Our reference: EF13/2664
Contact: Matthew Rizzuto (02) 62297002 or queanbeyan@epa.nsw.gov.au

Dargues Gold Mine Project MOD 3 (MP 10_0054) Response to Submissions

ATTACHMENT A

Environment Protection Authority comments on Big Island Mining Pty Ltd "Response to Submissions for the Dargues Gold Mine Amended Modification Request (Modification 3 MP10_0054)"

| DRAWING TITLE   |            |             |     |
|---|------------|-------------|-----|
| 13000046  | P03        | ESCP07      | 01  |

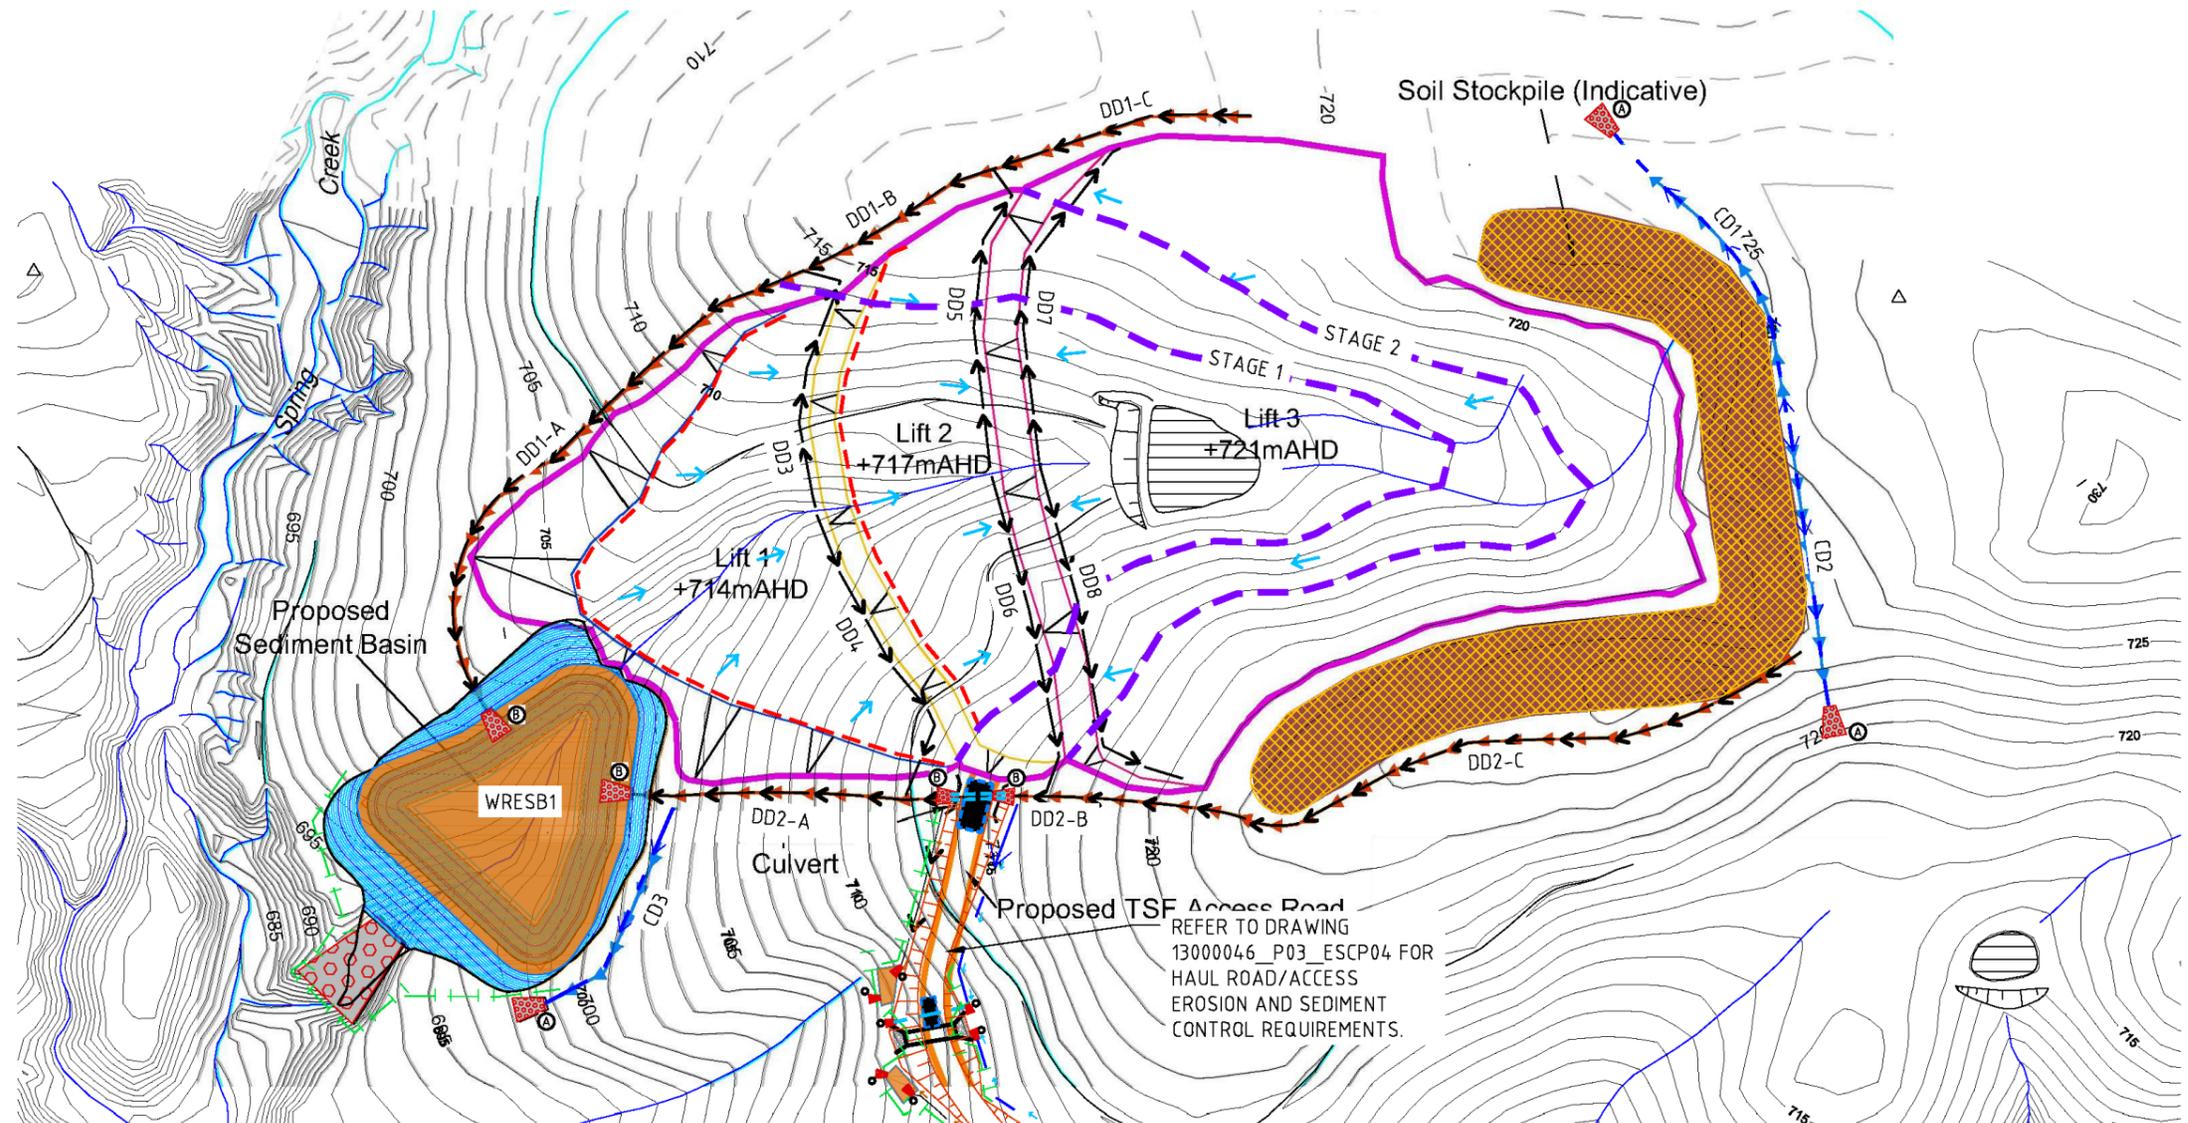
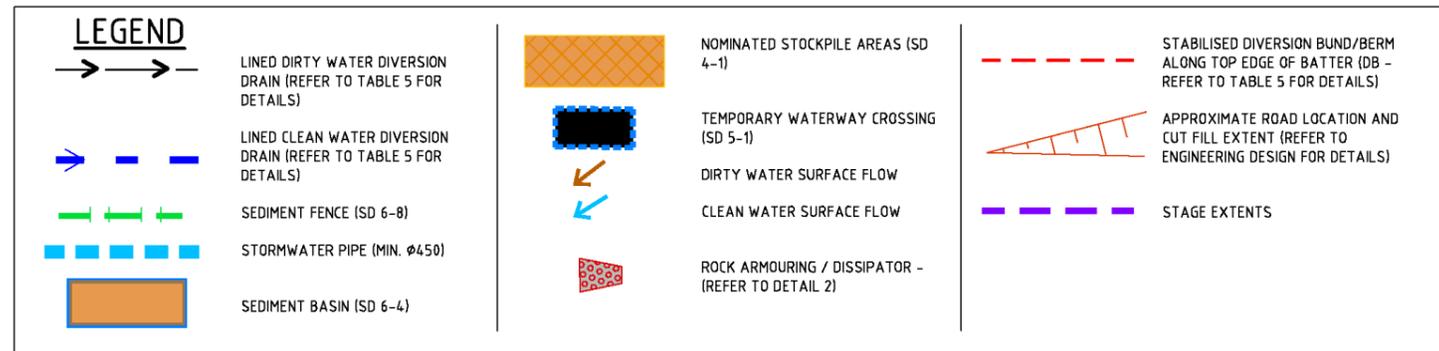
The proponent has not provided information to confirm that the performance criteria of a 1 in 20 year 48 hour rainfall capacity for the sediment basin associated with the Eastern Waste rock Emplacement can be achieved. In order to address these issues the applicant should provide the information that the EPA requested in its submission.
